CITY OF ALBUQUERQUE

Re: 1010 Pipe and Casing
5609 Alameda Pl. NE
Traffic Circulation Layout
Architect's Stamp 03-XX-23 (C18-D015)

Based upon the information provided in your submittal received 07-11-23, the above referenced plan cannot be approved for Building Permit until the following comments are addressed:

1 Site Plan

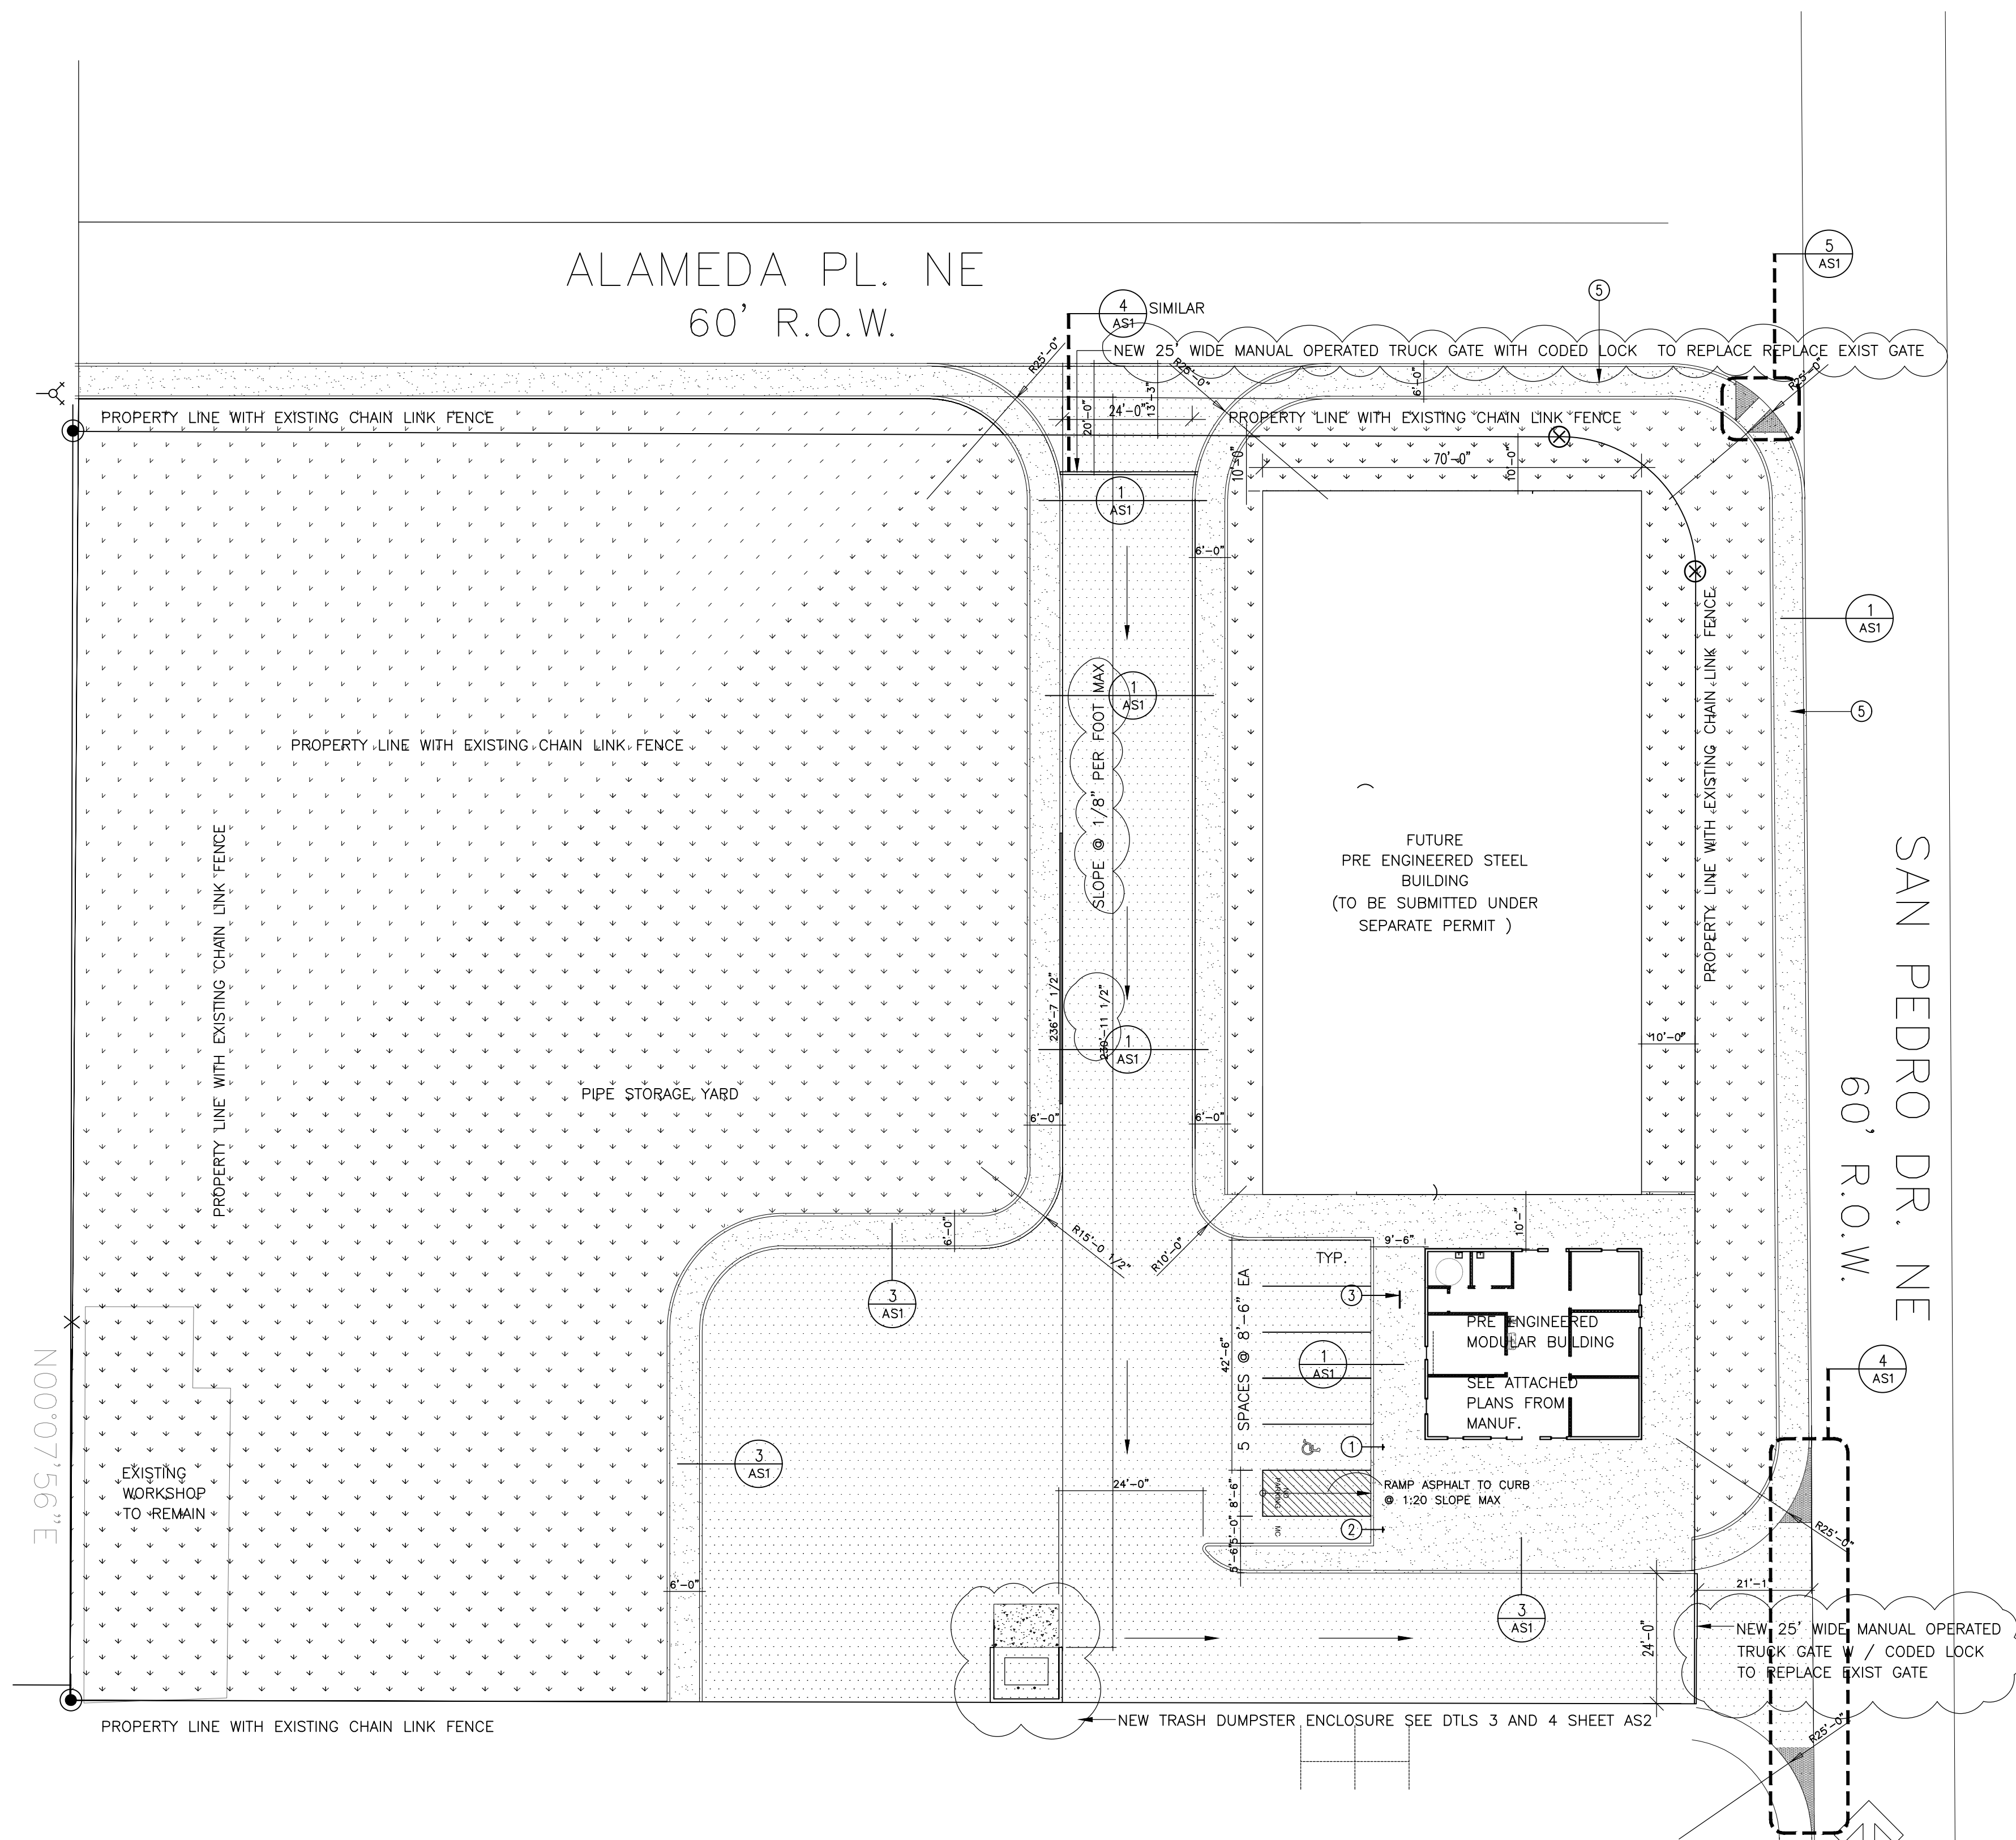
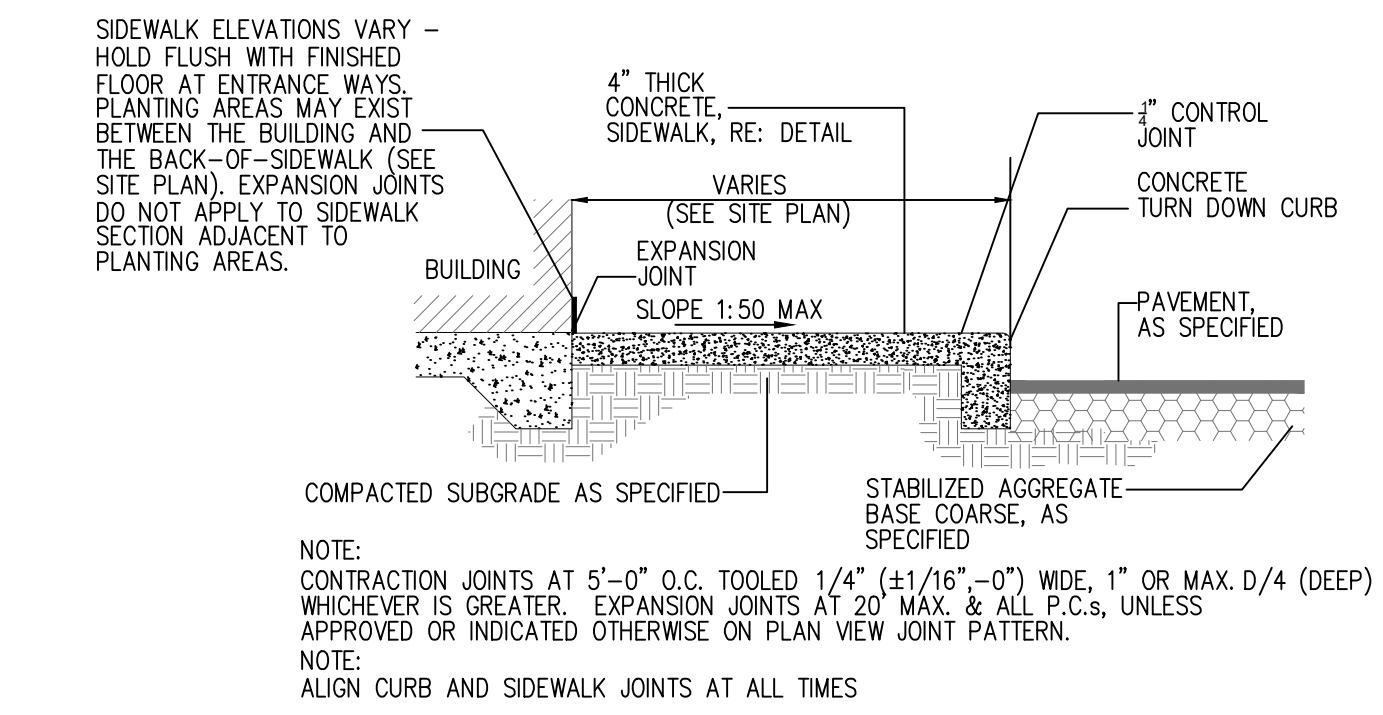
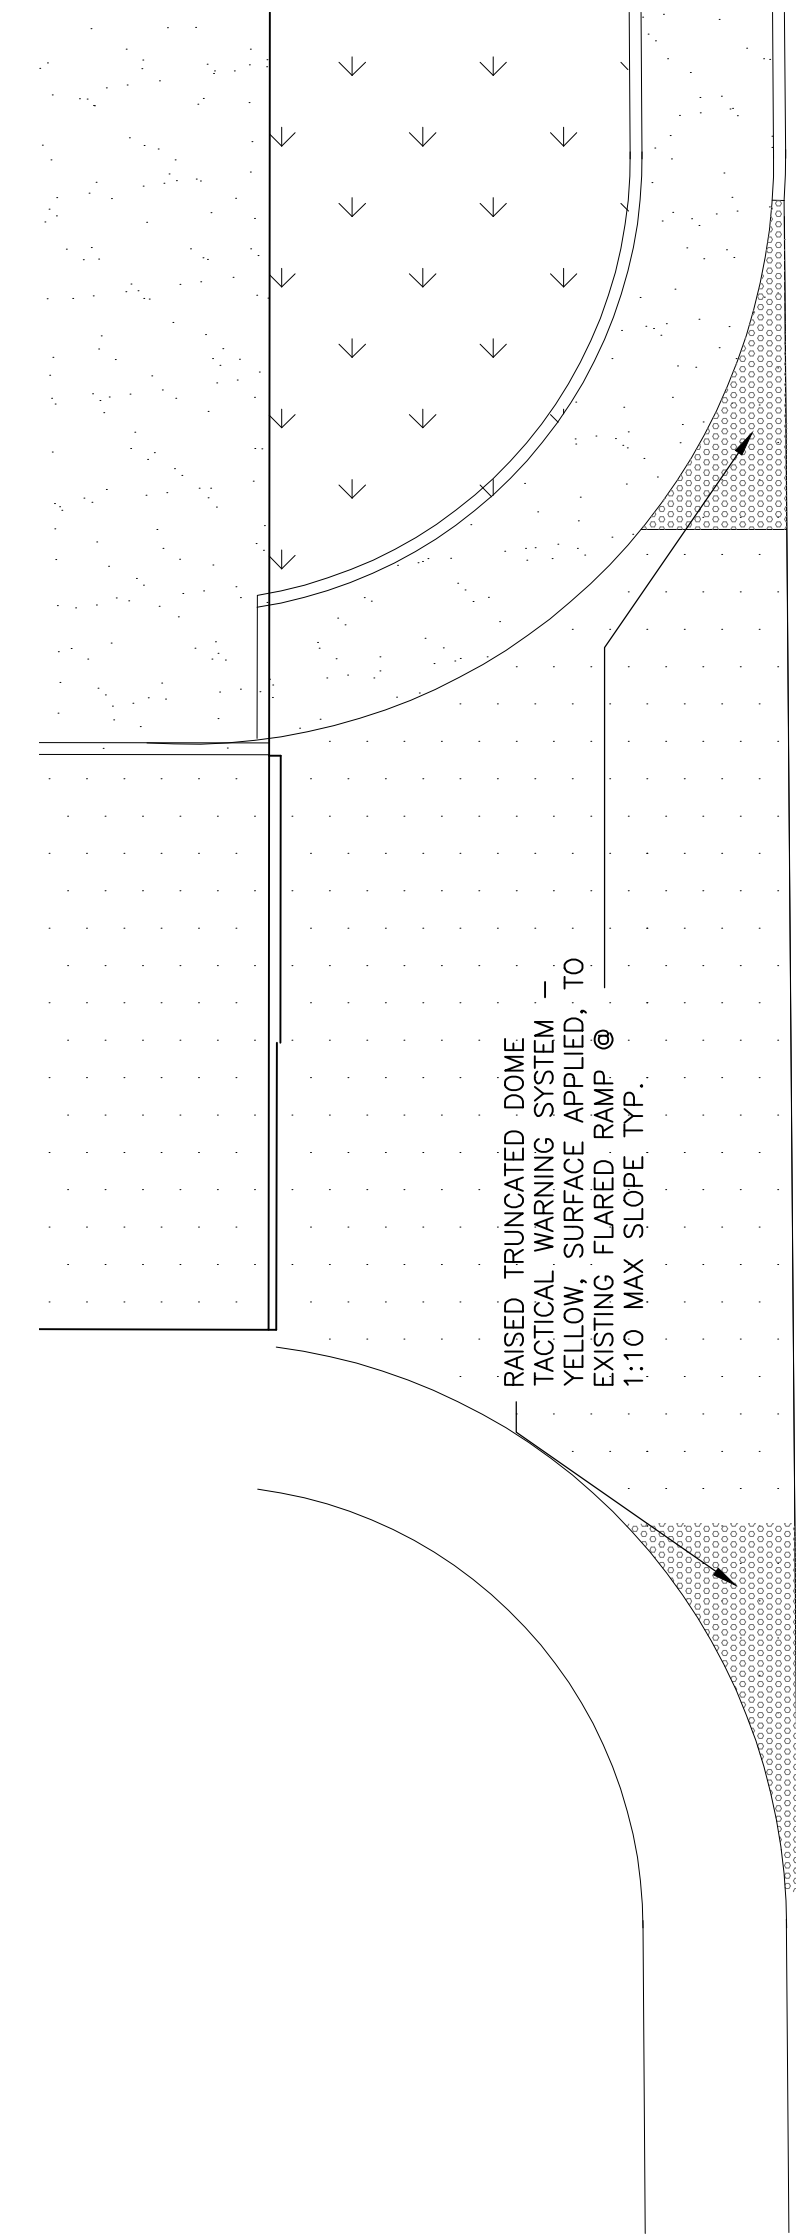
1. List the number of Bicycle parking spaces required by the IDO.
2. The traffic circulation layout must be dated by an engineer or architect licensed in the state of New Mexico.

3. Identify all existing access easements and rights of way width dimensions.
4. Identify the right of way width, medians, curb cuts, and street widths on Alameda Pl. and San Pedro Dr.

5. Please provide design details for both proposed driveways and reference COA std dwg.
6. ADA curb ramp at the corner of Alameda Pl. and San Pedro Dr. must be built to current standards and have truncated domes installed. Please provide design details and reference COA std dwg.

7. Please reference COA std dwg 2430 for the proposed sidewalk.
8. Please show on the site plan a minimum 20 ft. setback for the proposed gates.
9. It appears that the proposed driveway off San Pedro will encroach with the south side adjacent property. Please provide adjacent property owner agreement.

10. Details sheet is missing.
11. The ADA accessible parking sign must have the required language per 66-7-352.4C NMSA 1978 **"Violators Are Subject to a Fine and/or Towing."** Please call out detail and location of signs.

12. The pavement marking "MC" should be shown in the opposite direction for motorcycles entering the parking space.
13. All bicycle racks shall be designed according to the following guidelines:

14. Bicycle racks shall be sturdy and anchored to a concrete pad.
15. A 1-foot clear zone around the bicycle parking stall shall be provided.
16. Bicycle parking spaces shall be at least 6 feet long and 2 feet wide.

17. Per DPM, a 6 ft. wide ADA accessible pedestrian pathway is required from the ADA parking stall access aisles to the building entrances. Please clearly show this pathway and provide details.

18. ADA accessible pedestrian pathway should not be placed behind parking space or adjacent to a vehicular way. Vehicle and pedestrian/wheel chair conflicts should be avoided as much as possible.

19. Curbing should be installed to delineate landscape, parking, and pedestrian ways and identify points of access. Please call out detail and location of barrier curb.

20. Refuse vehicle maneuvering shall be contained on-site. The refuse vehicle shall not back into the public right of way.; provide a copy of refuse approval.

21. Provide a copy of Fire Marshal approval.
22. Show the clear sight triangle and add the following note to the plan: "Landscaping and signage will not interfere with clear sight requirements. Therefore, signs, walls, trees, and shrubbery between 3 and 8 feet tall (as measured from the gutter pan) will not be acceptable in the clear sight triangle.

25. Please add a note on the plan stating "All improvements located in the Right of Way must be included on the work order."
